The Planning Inspectorate

Our Ref: TR050006

Planning Act 2008 (as amended) – Section 51

Application by Roxhill (Junction 15) Limited for an Order Granting Development Consent for the Northampton Gateway Rail Freight Interchange

Sheet 6 Location Plan (1:50,000)

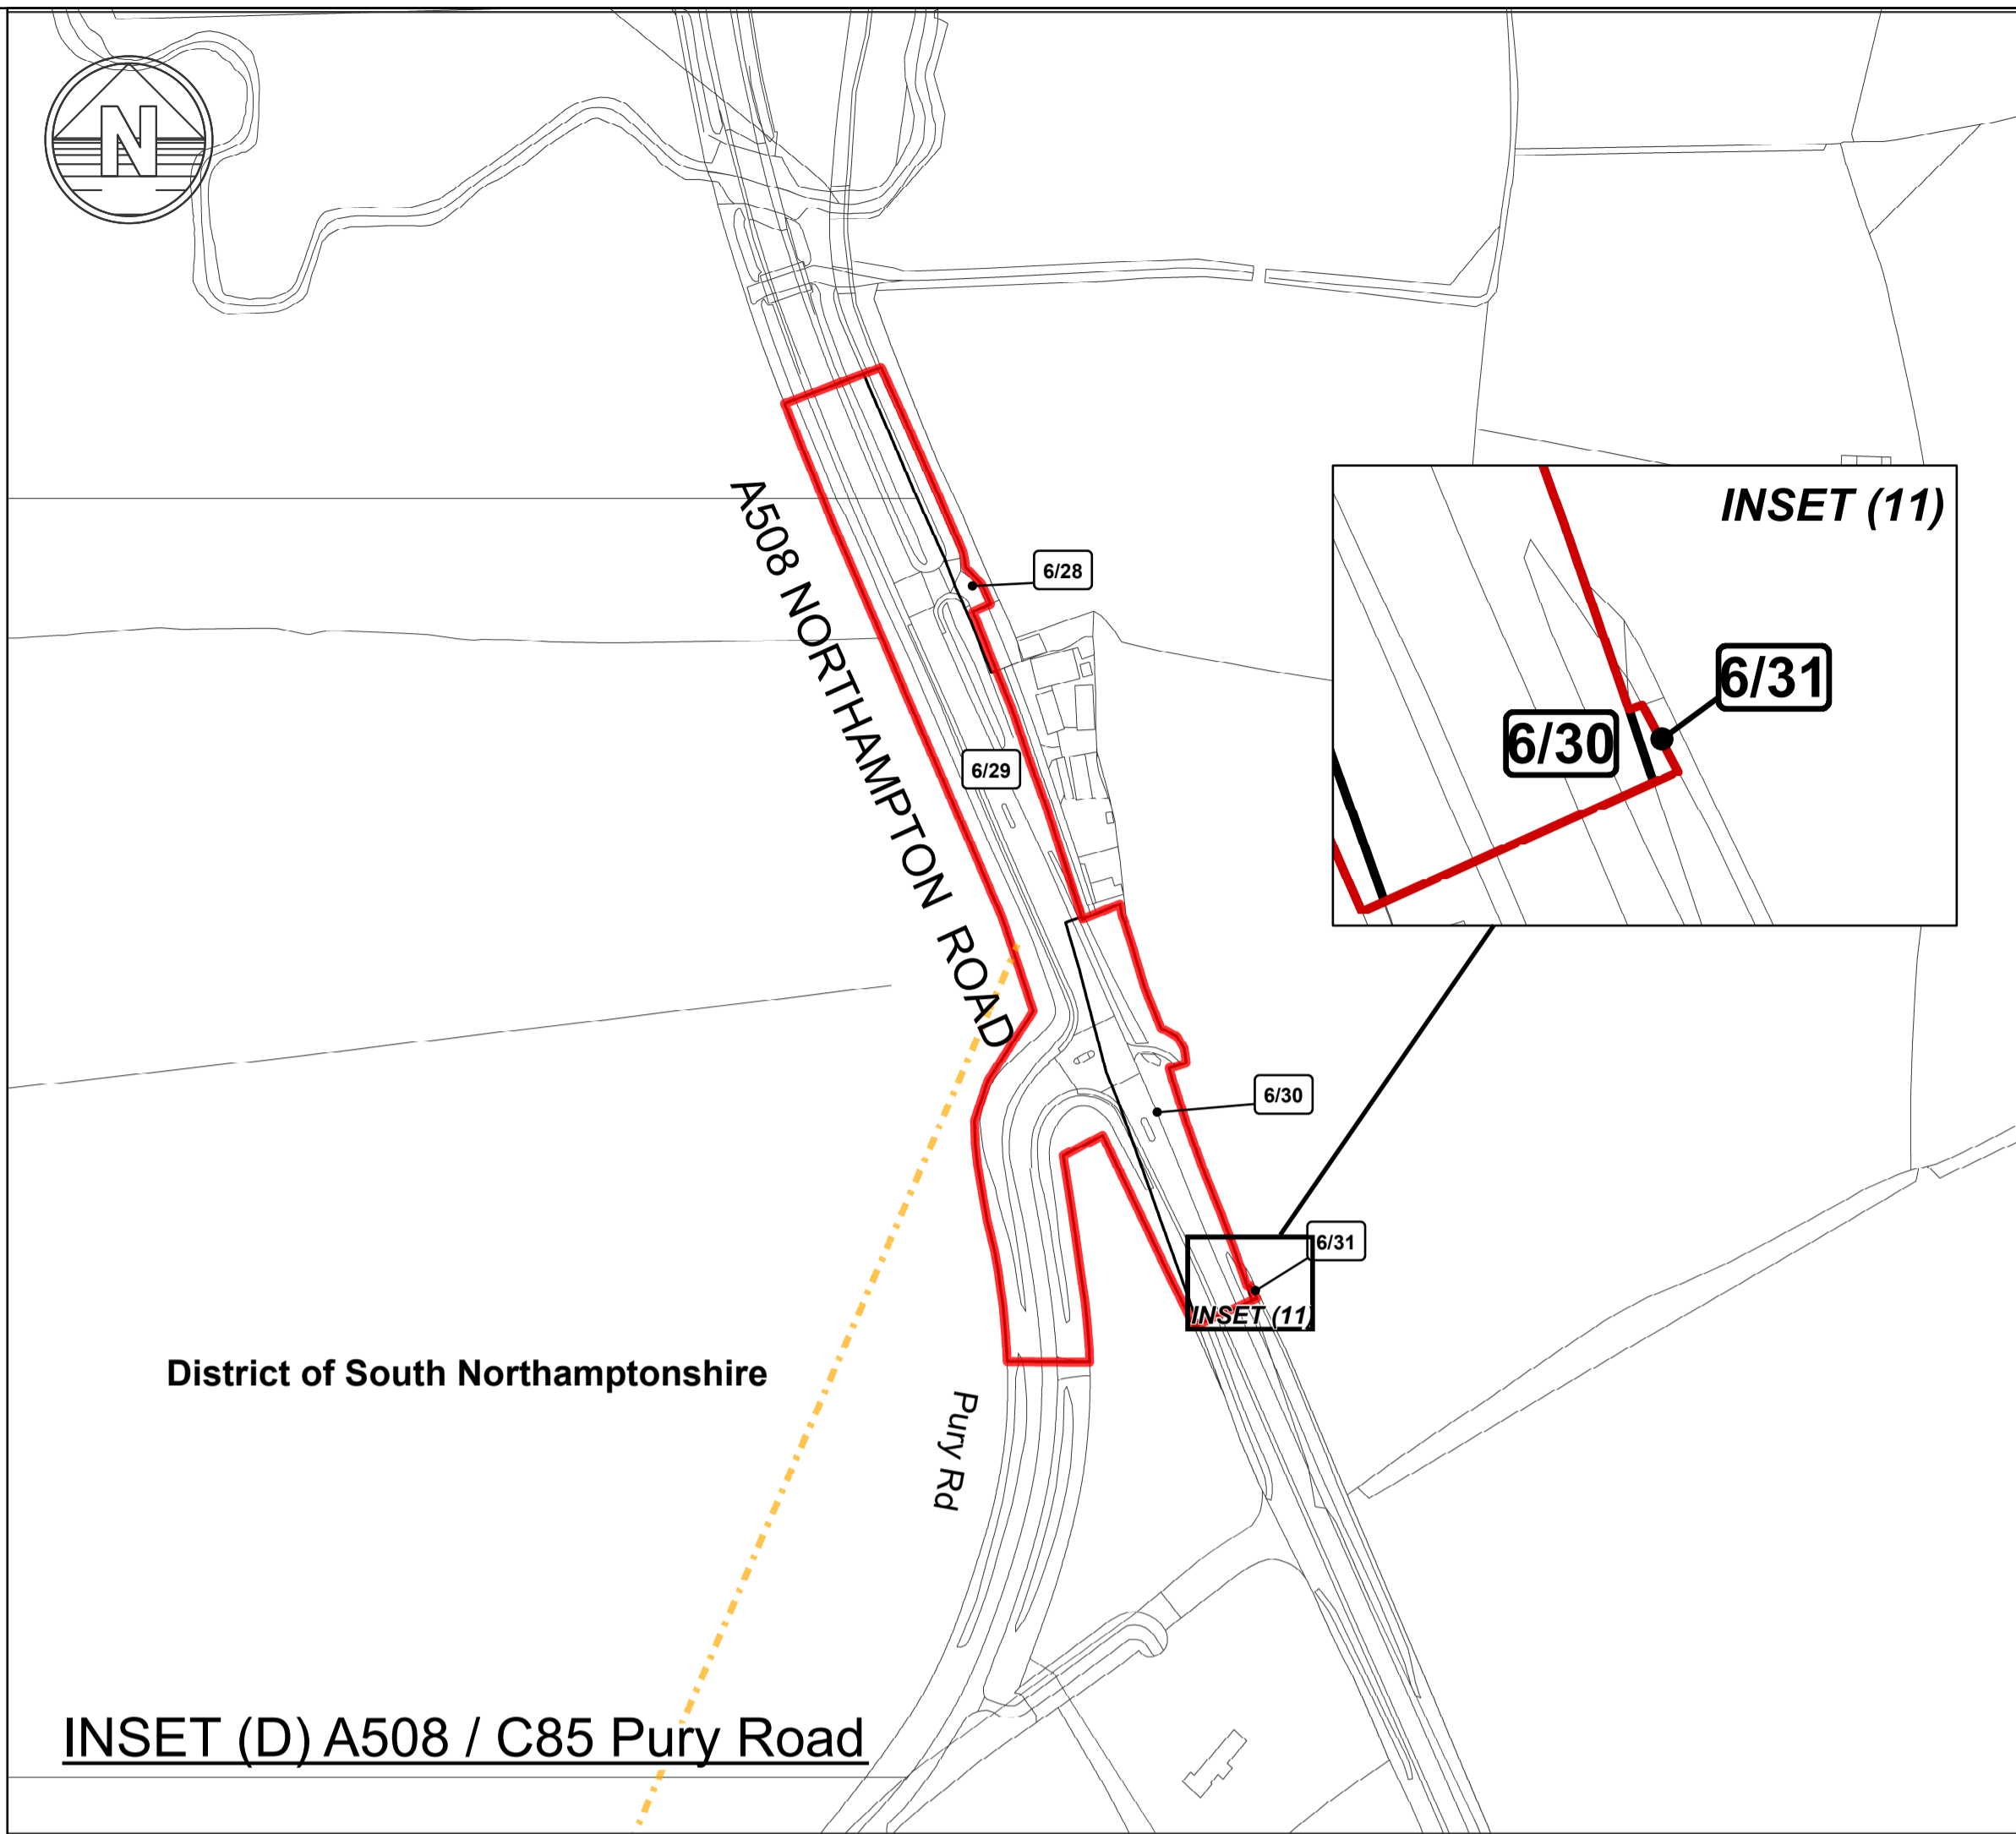
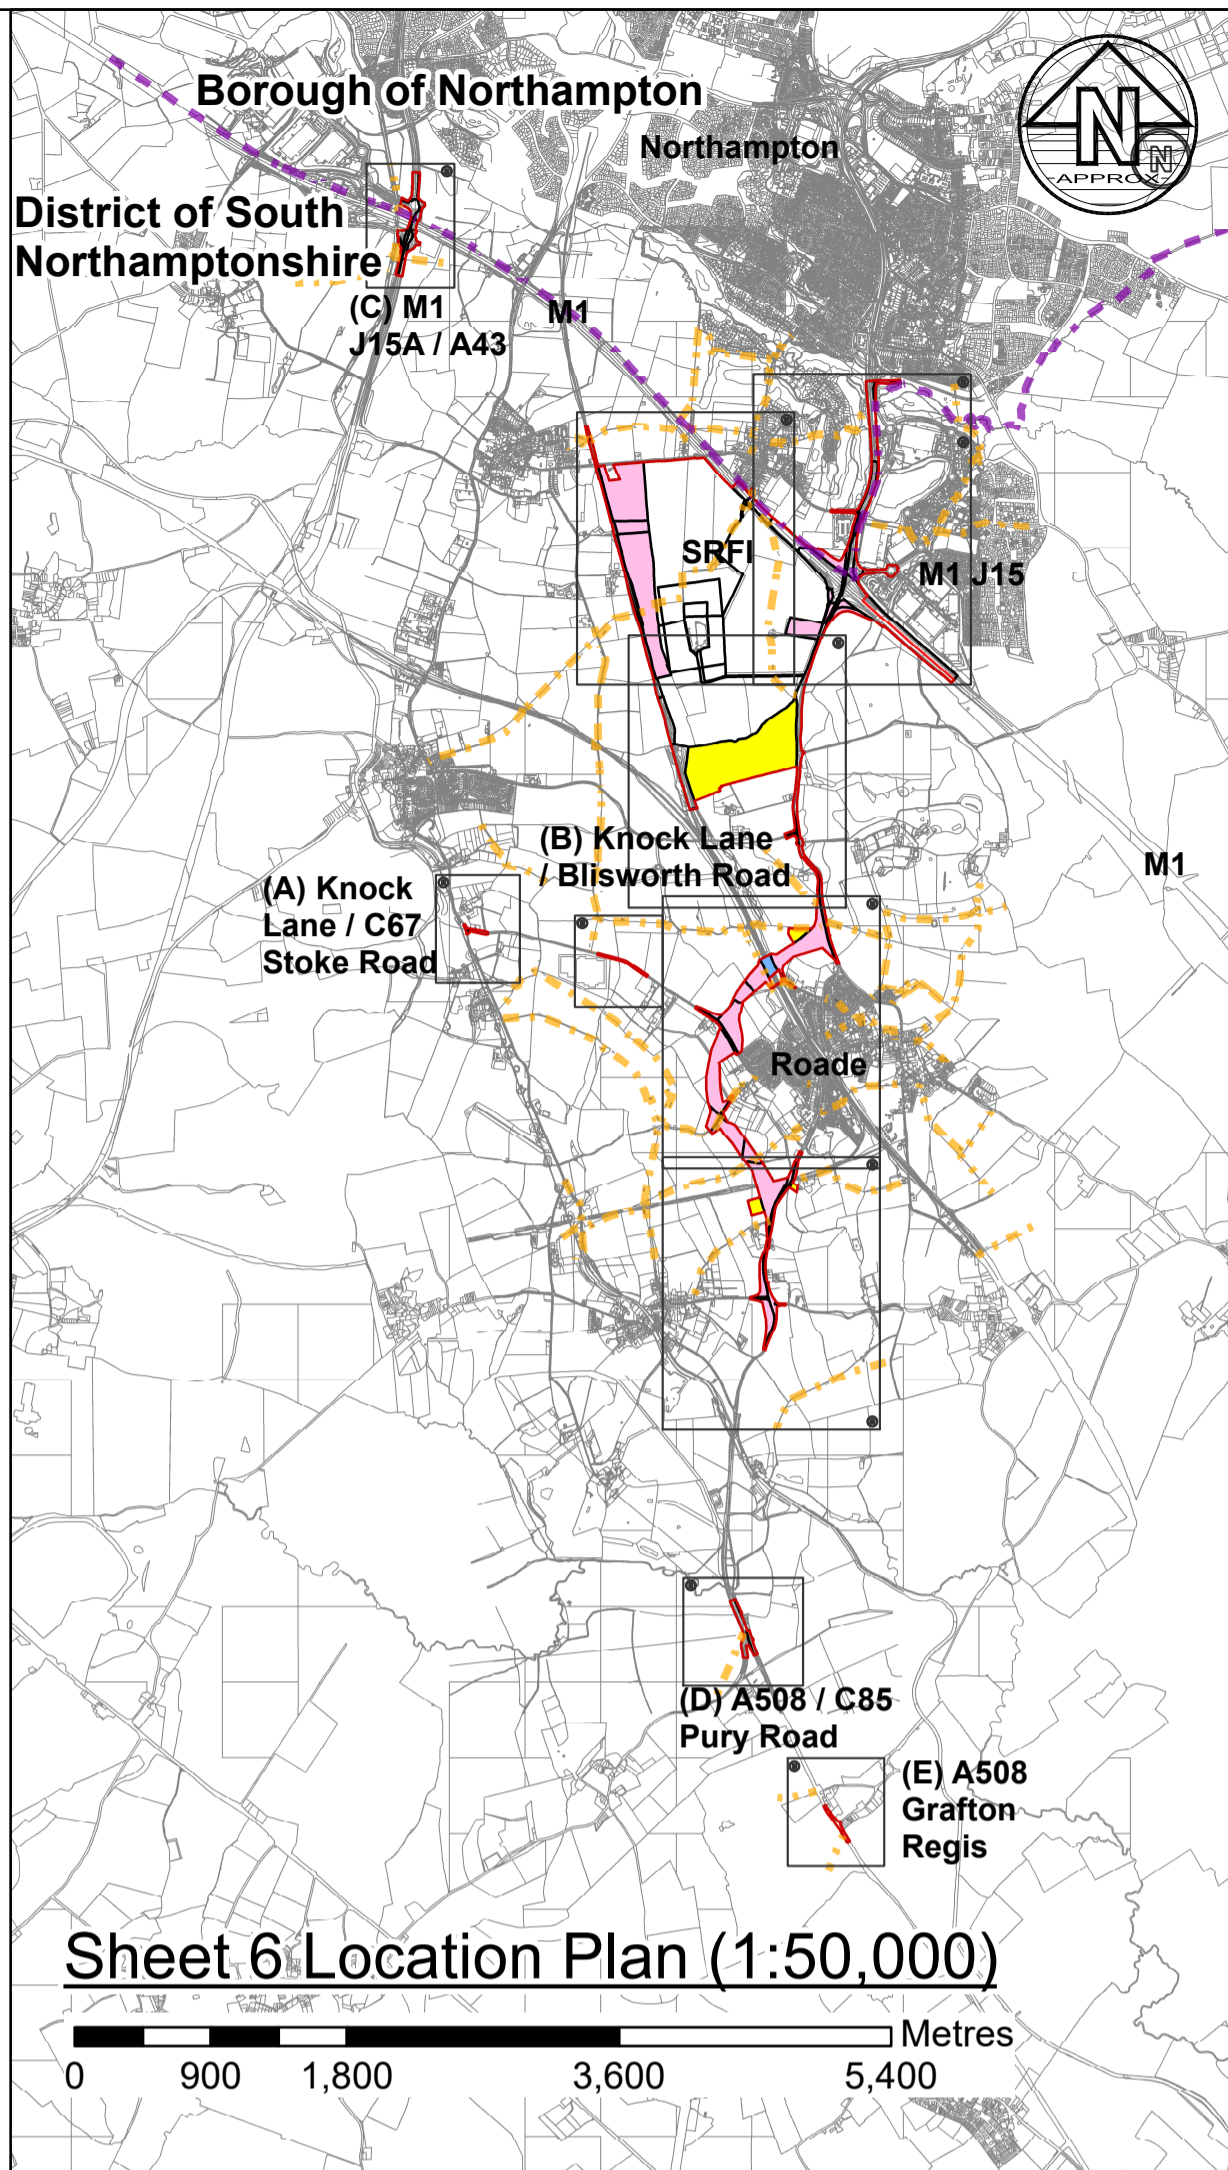
The following plots on the land plans cannot be seen clearly: 2/29, 6/8, 6/12, 6/15 & 6/16. On sheet 6 of the land plans the point at which plots 6/5, 6/6, 6/8 & 6/9 meet is unclear. The Applicant should consider providing updated plans.
